Ribble Valley Borough Council
Housing & Development Control

Application no: **3/2022/0777**

Address: **Teewood Farm Barns Slaidburn Road Waddington BB7 3JJ**

The Local Highway Authority have viewed the plans and highway related documents and have the following comments to make:

Proposed Site Access

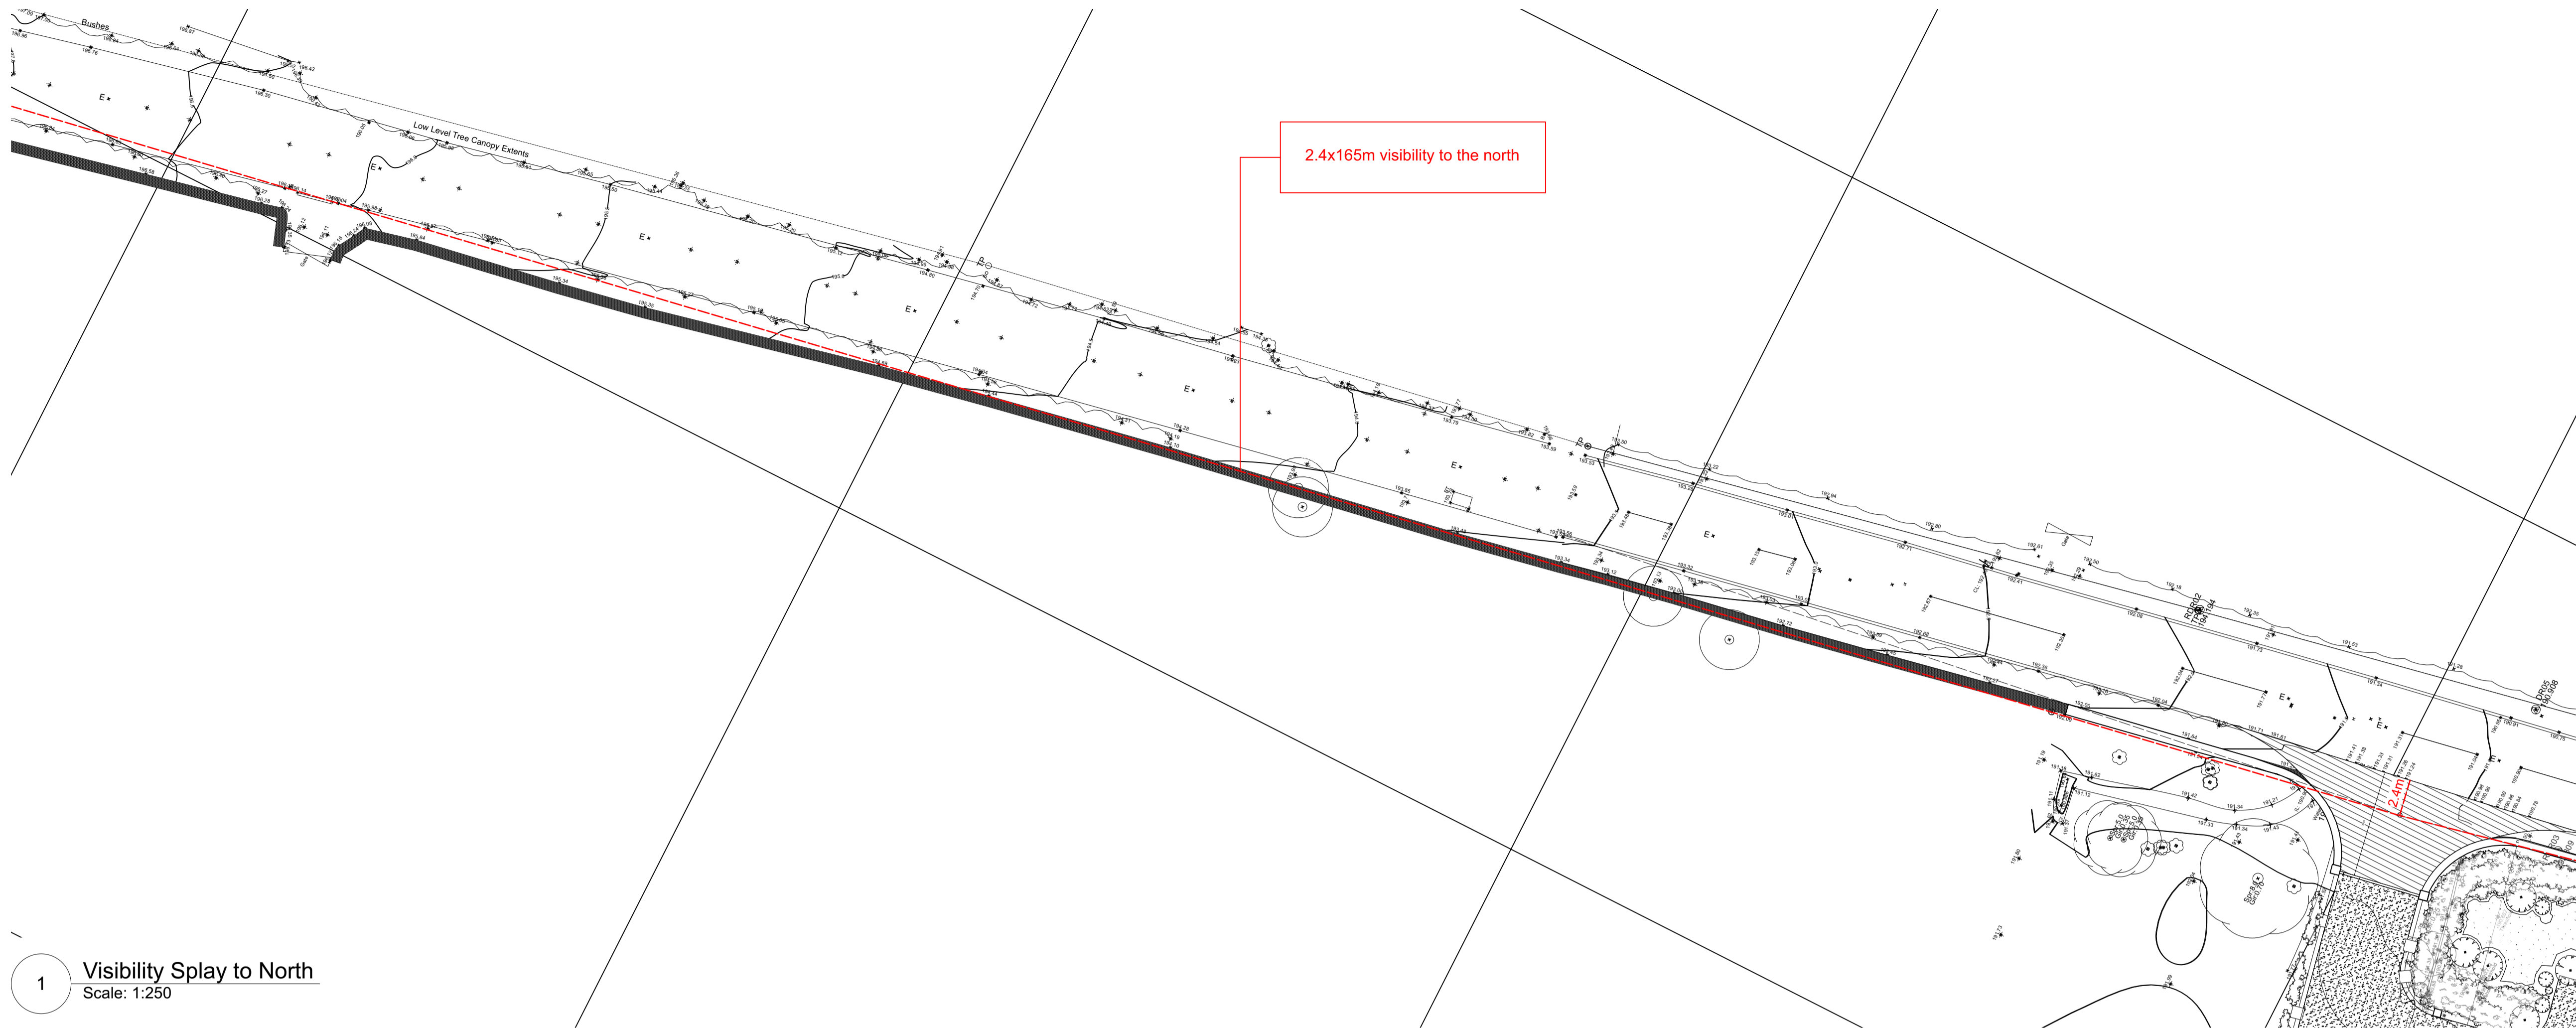
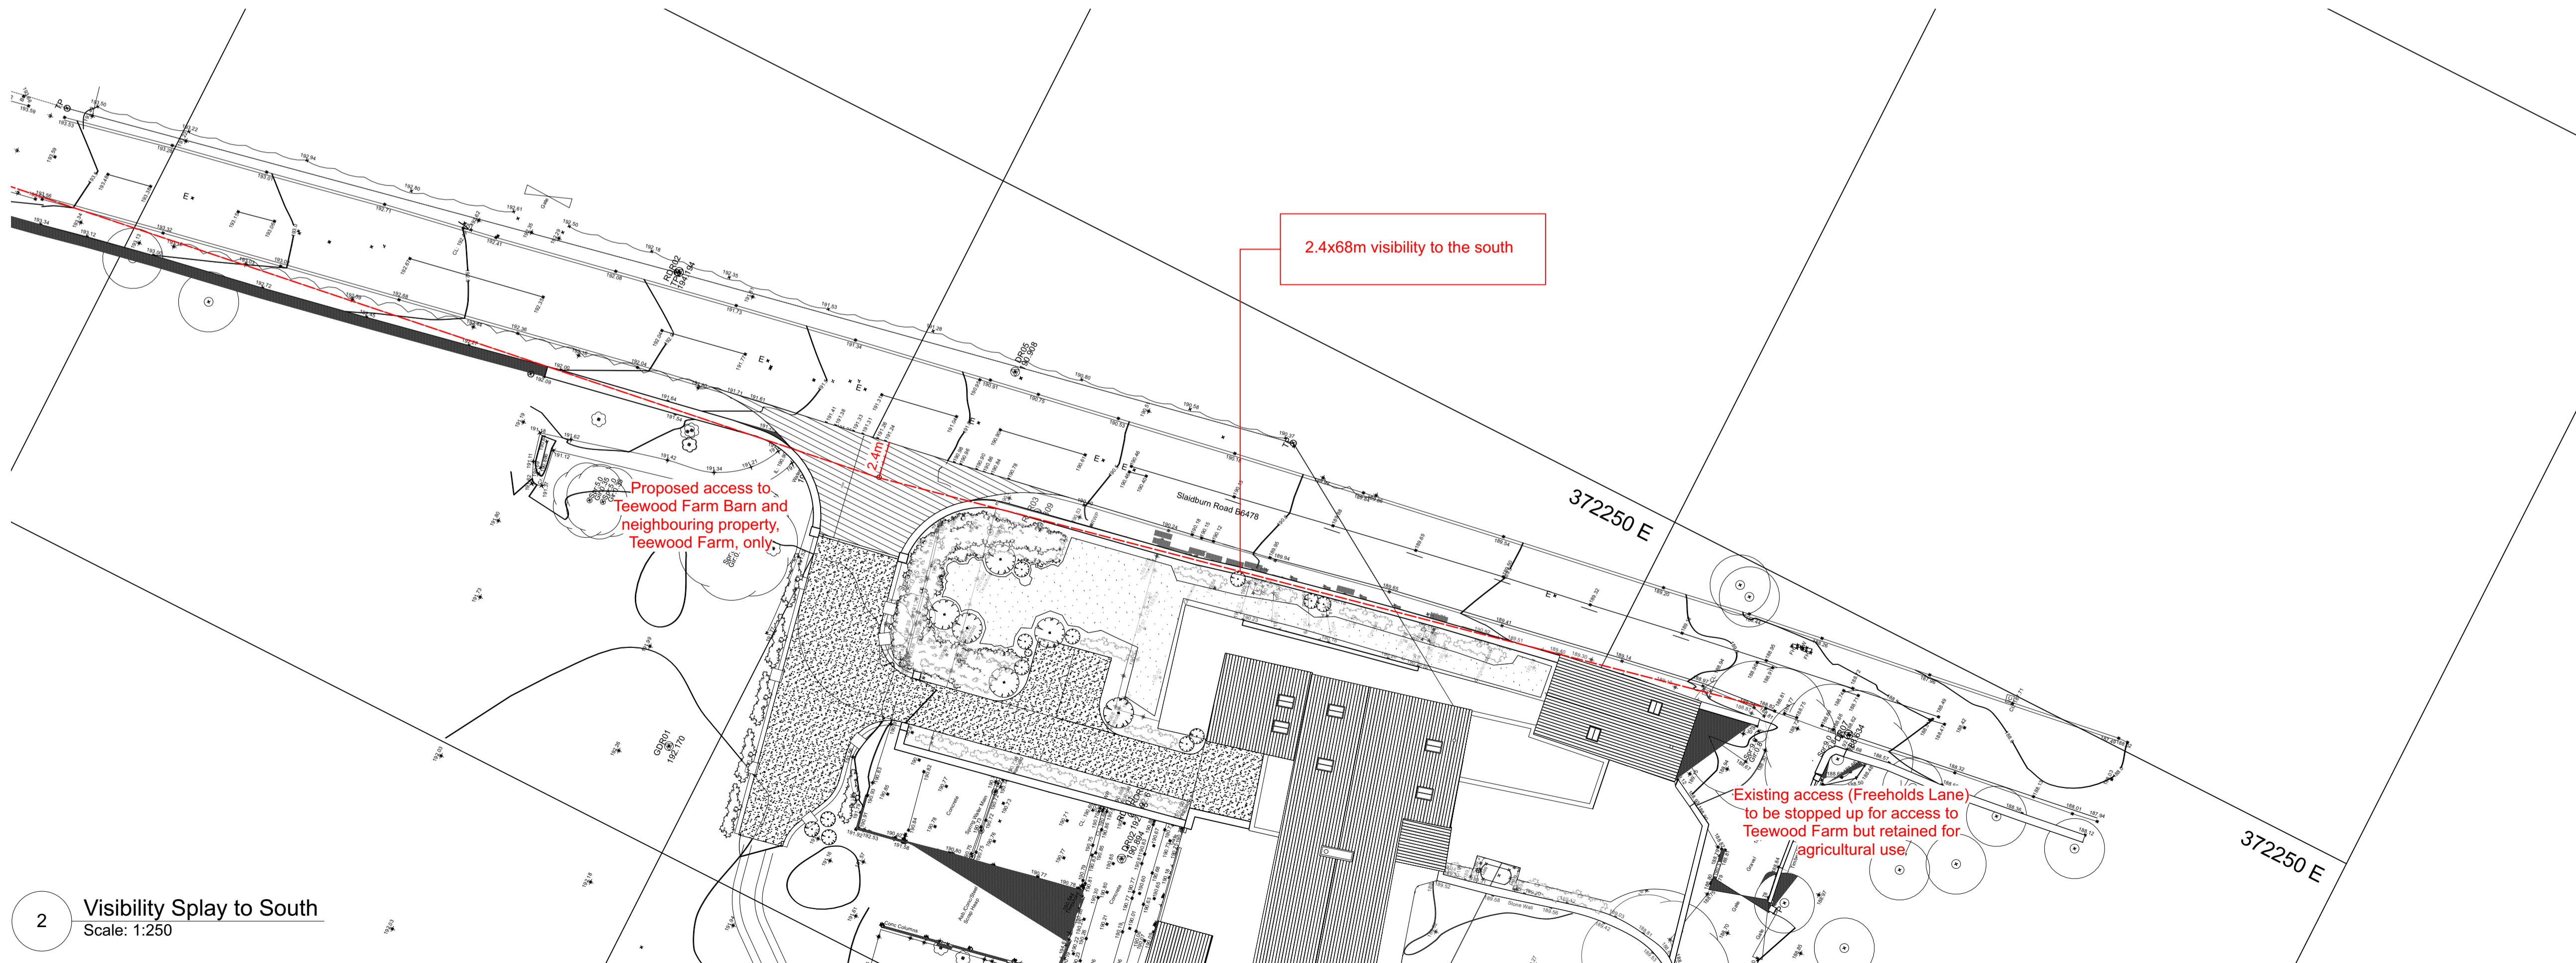
However, the LHA have reviewed Define drawing number 046_PLN_204 Rev A titled "Proposed Site Access" and are aware that the site access can only provide visibility splays of 2.4m x 165m to the left and 2.4m x 68m to the right of the access. This does not comply with the LHAs guidance for a 60mph road, with the LHA requiring visibility splays of 2.4m x 214m in both directions.

Despite the shortfall in both directions, the LHA will accept the shortfall in visibility. This is because the existing access, which is located off Freeholds Lane, has minimal visibility due to the location of the existing outbuilding to the left and the vegetation and curvature along the adopted highway to the right of the access. Therefore, while the proposed access does not comply with the LHAs guidance, the access is better in terms of highway safety than the existing due to the access being able to achieve more visibility. As a result, of this the LHA will accept the shortfall and will have no objection to the creation of a new access.

3. No part of the development hereby permitted shall be occupied until such time as vehicular visibility splays of 2.4 metres by 165 metres to the left and 2.4 metres by 68 metres to the right have been provided at the site access. These shall thereafter be permanently maintained with nothing within those splays higher than 1 metres above the level of the adjacent footway/verge/highway.
